MEMO

TO: Nell Donaldson
FROM: Mike Farmer
DATE: April 7, 2015
RE: 195 Kennebec Street – site plan review

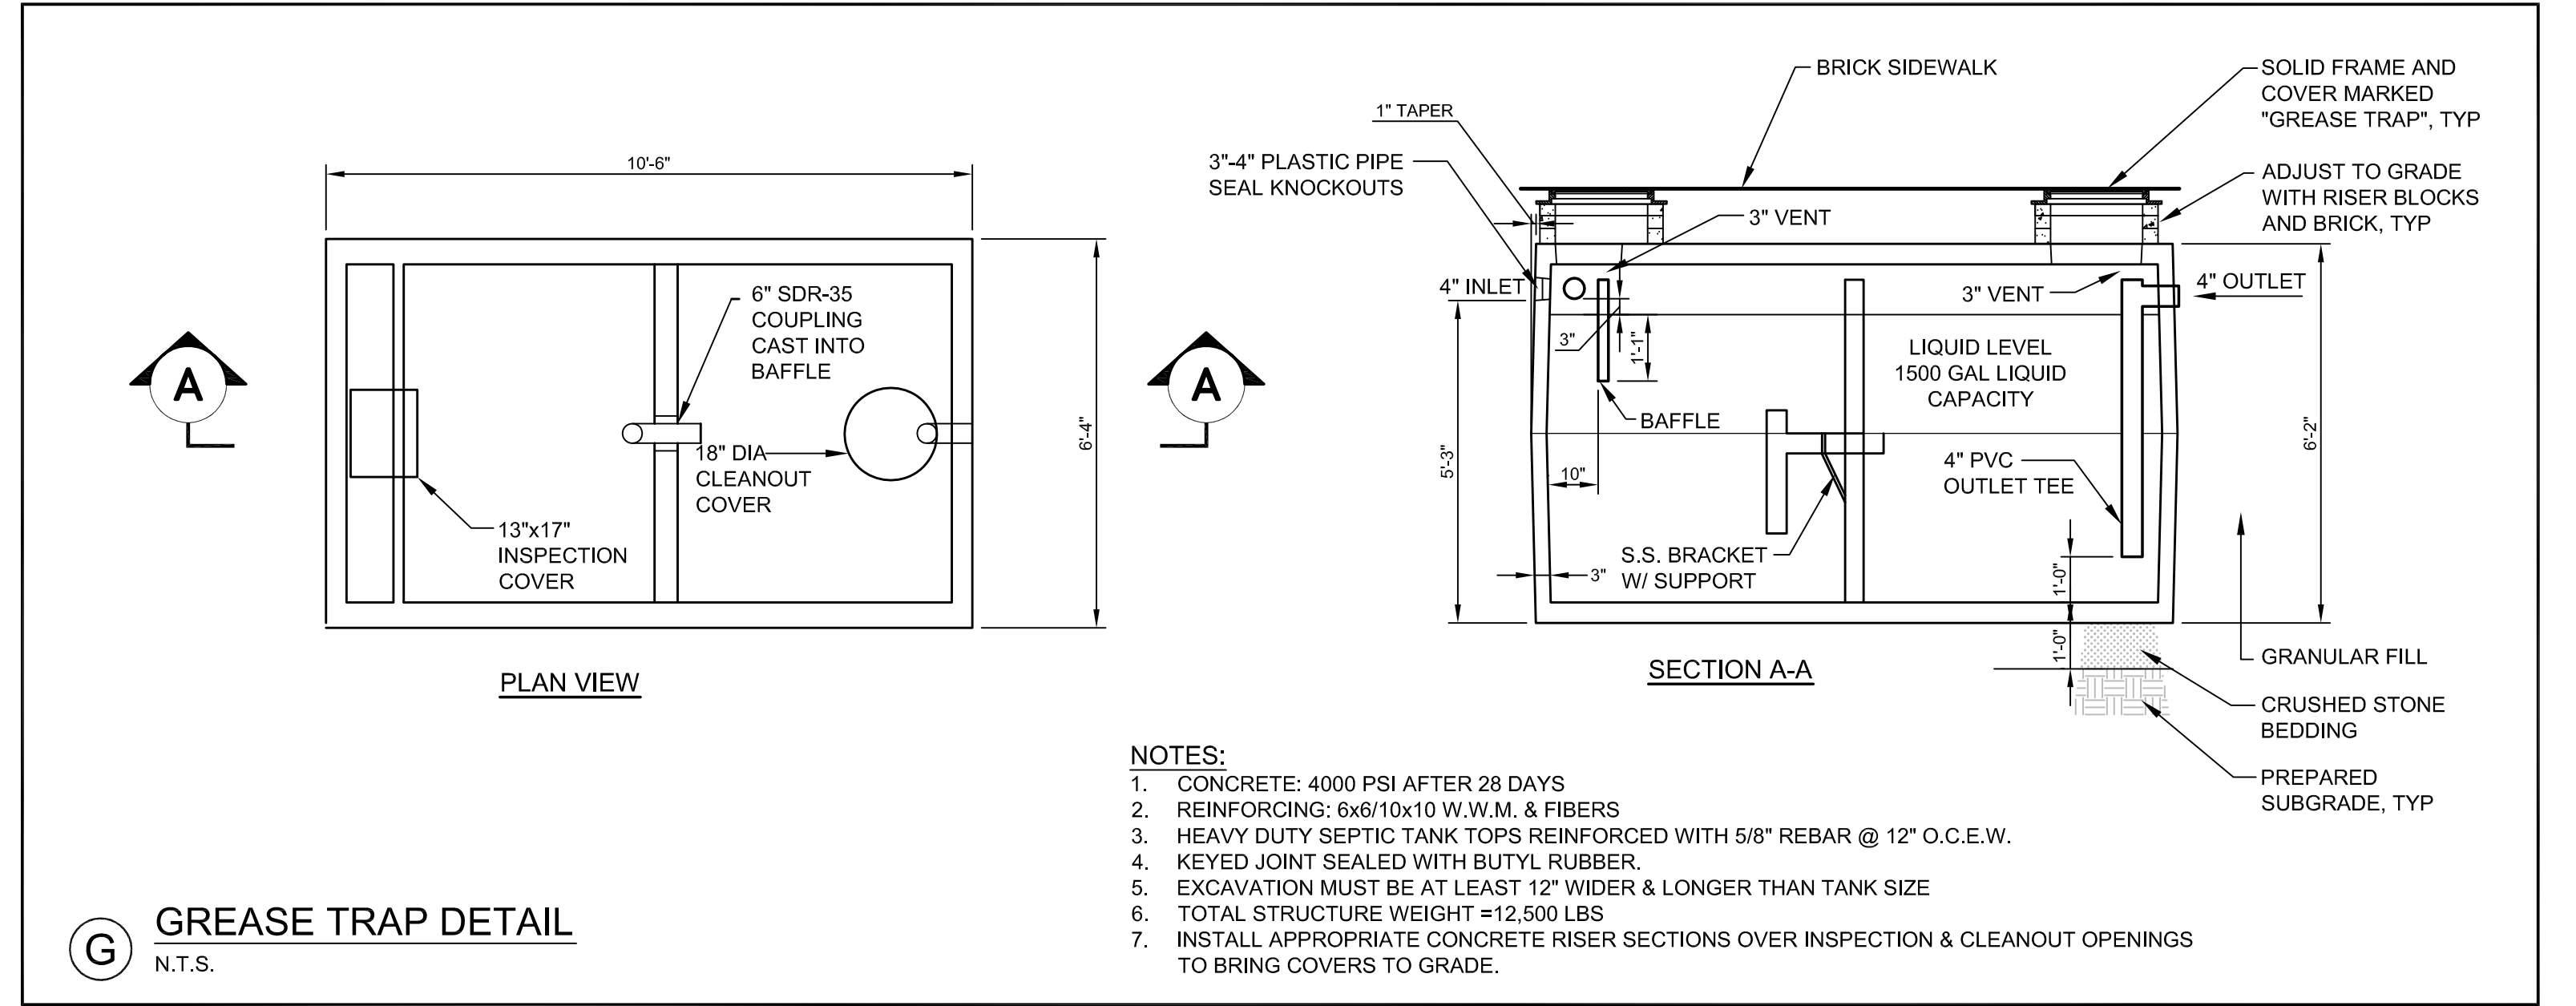
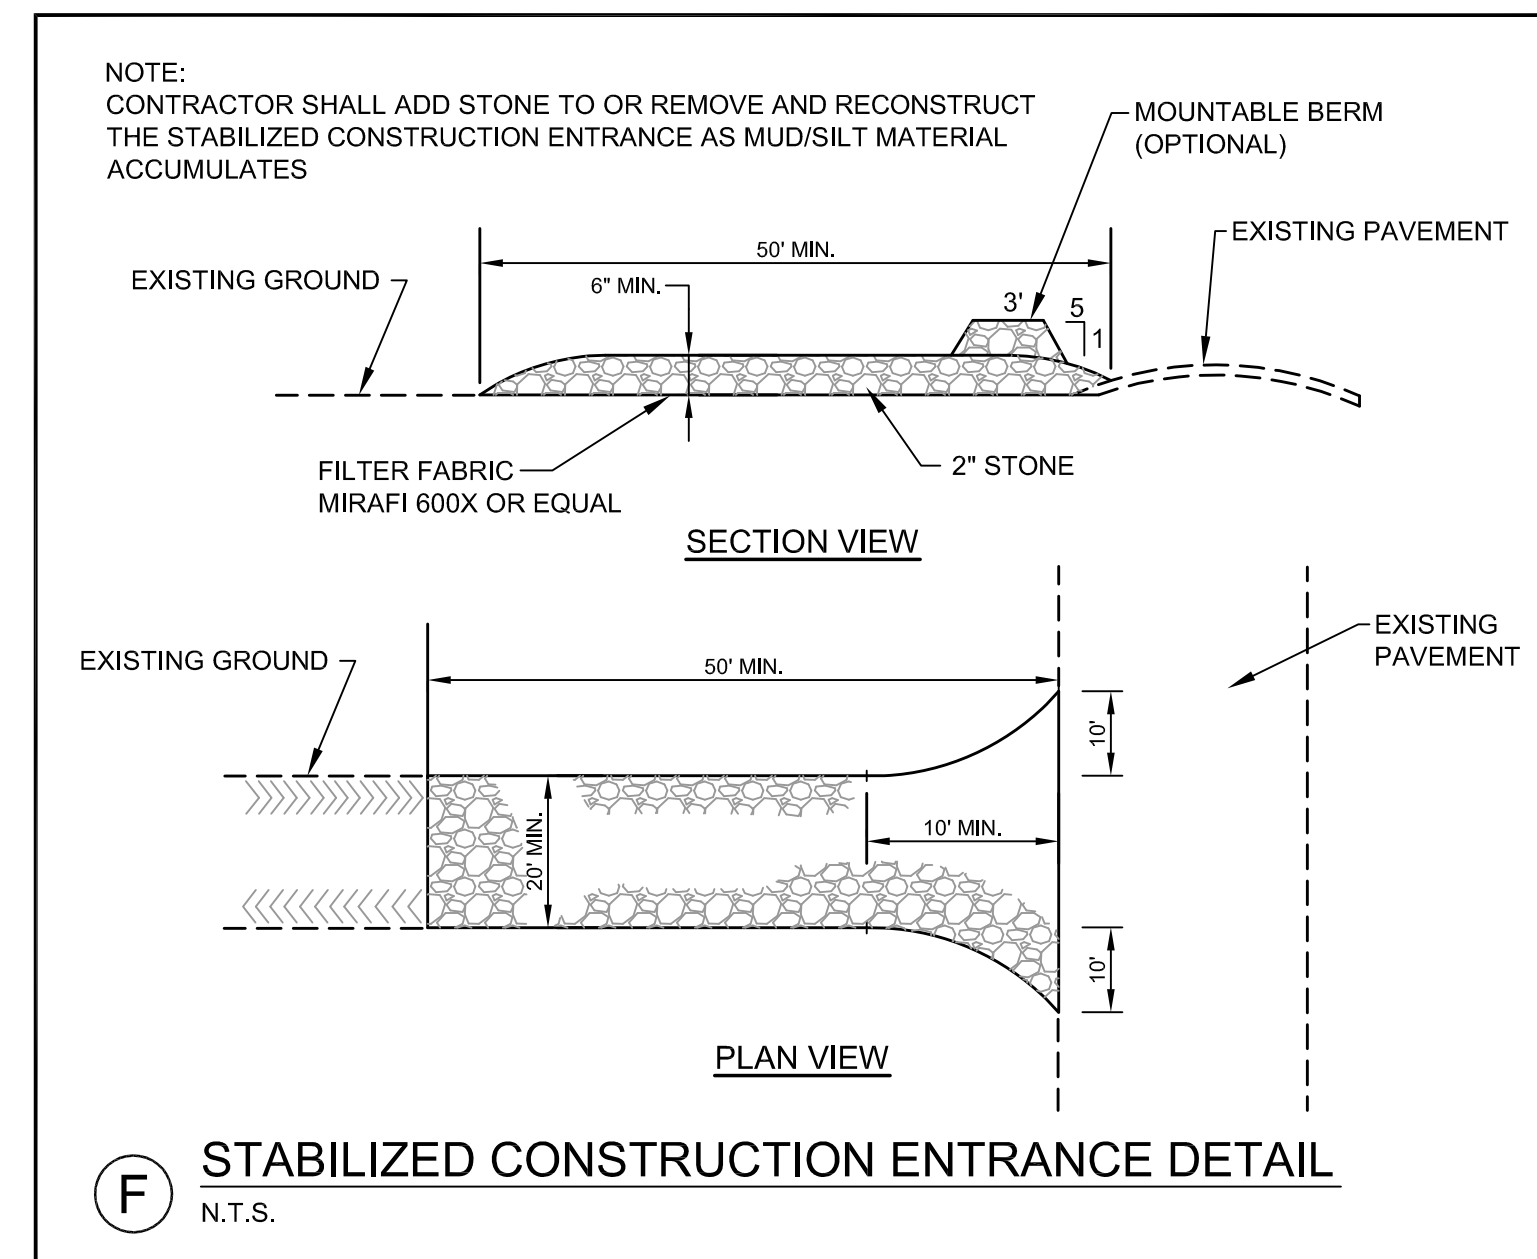
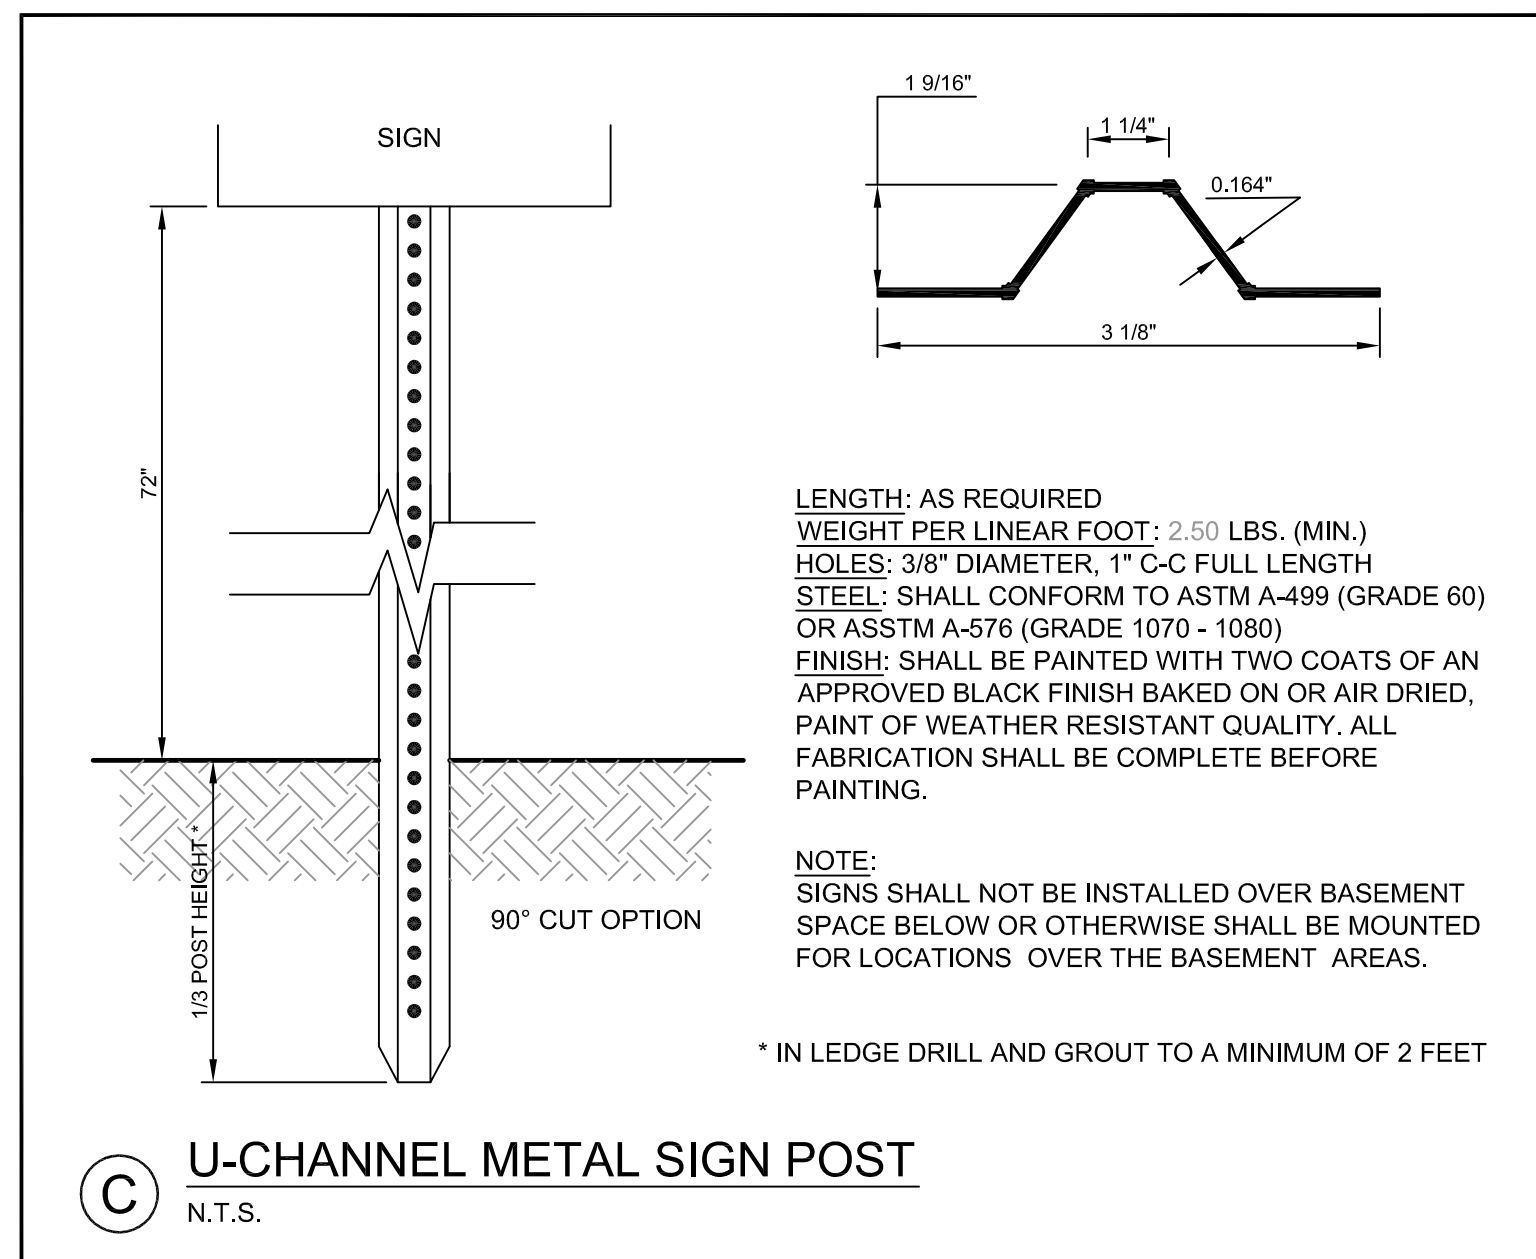
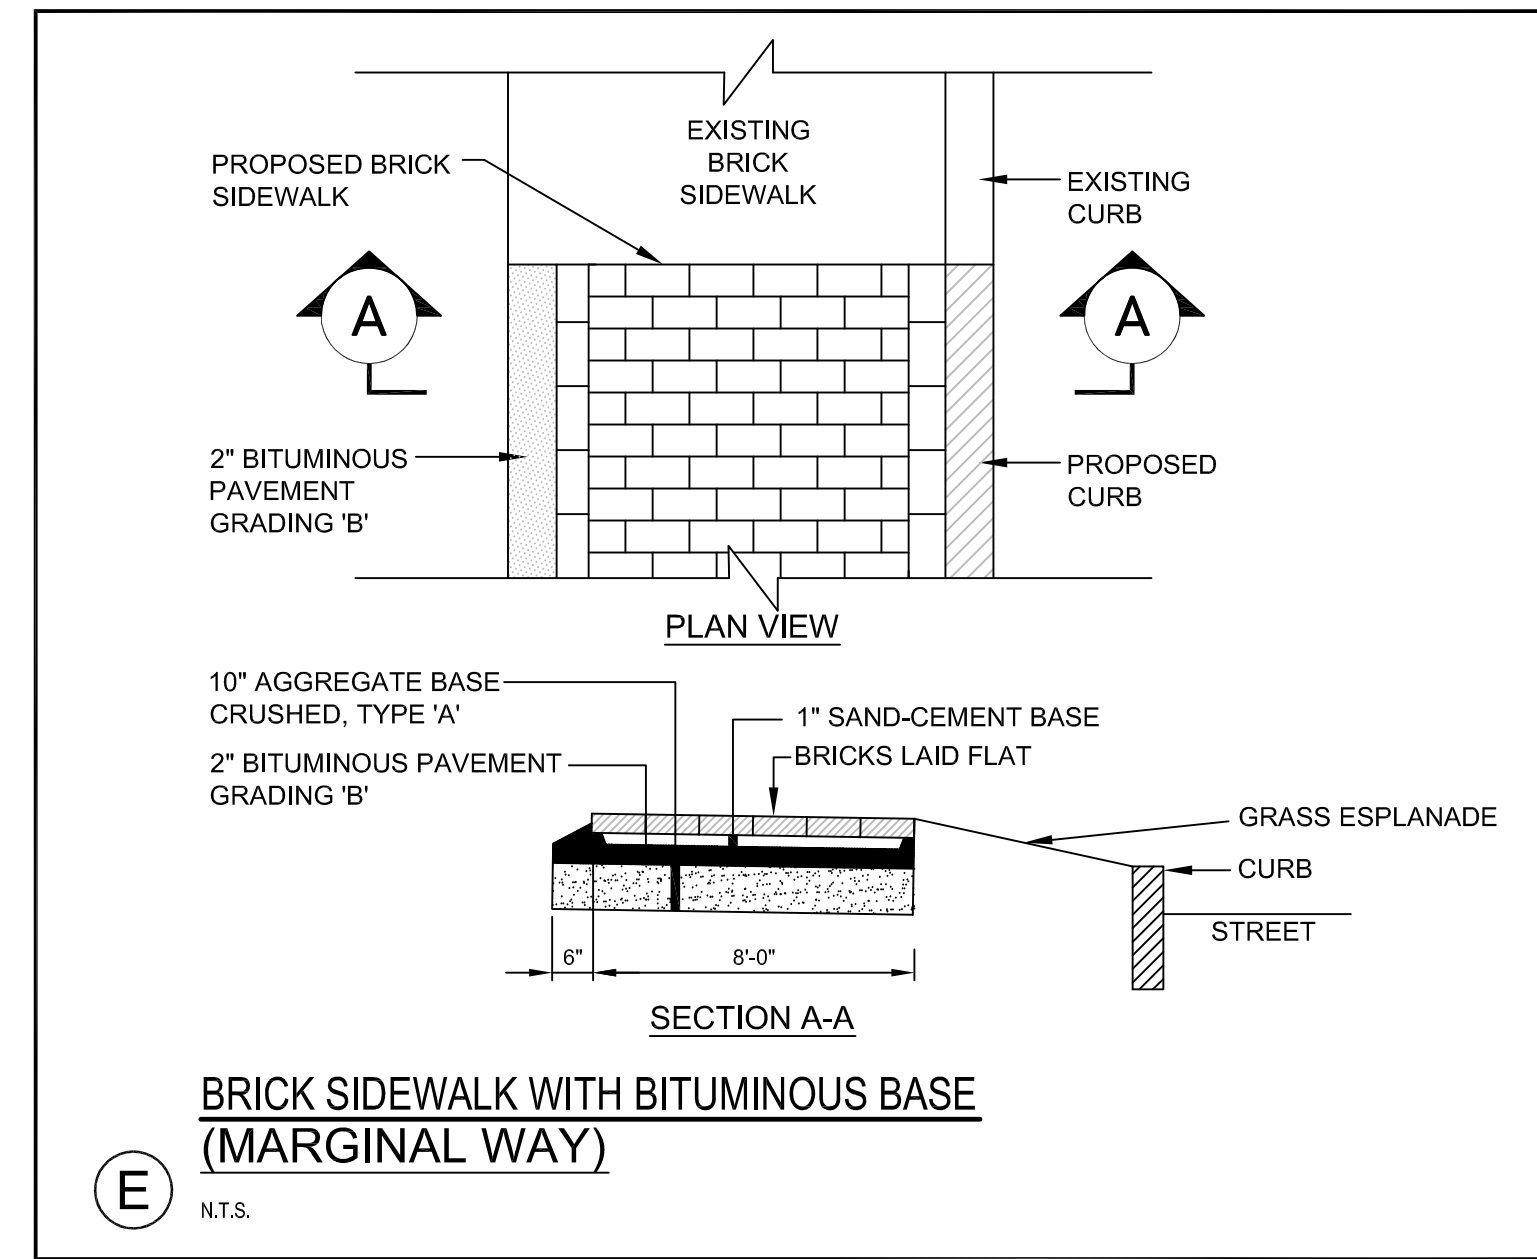
Detail C on plan sheet C-7.0, detail D on sheet C-7.2, and detail E on sheet C-7.2 all should be corrected to show the City standard for depth of base gravel for a brick sidewalk on bituminous base. The depth of gravel should be 10 inches, not 4 inches as indicated in the above referenced details.
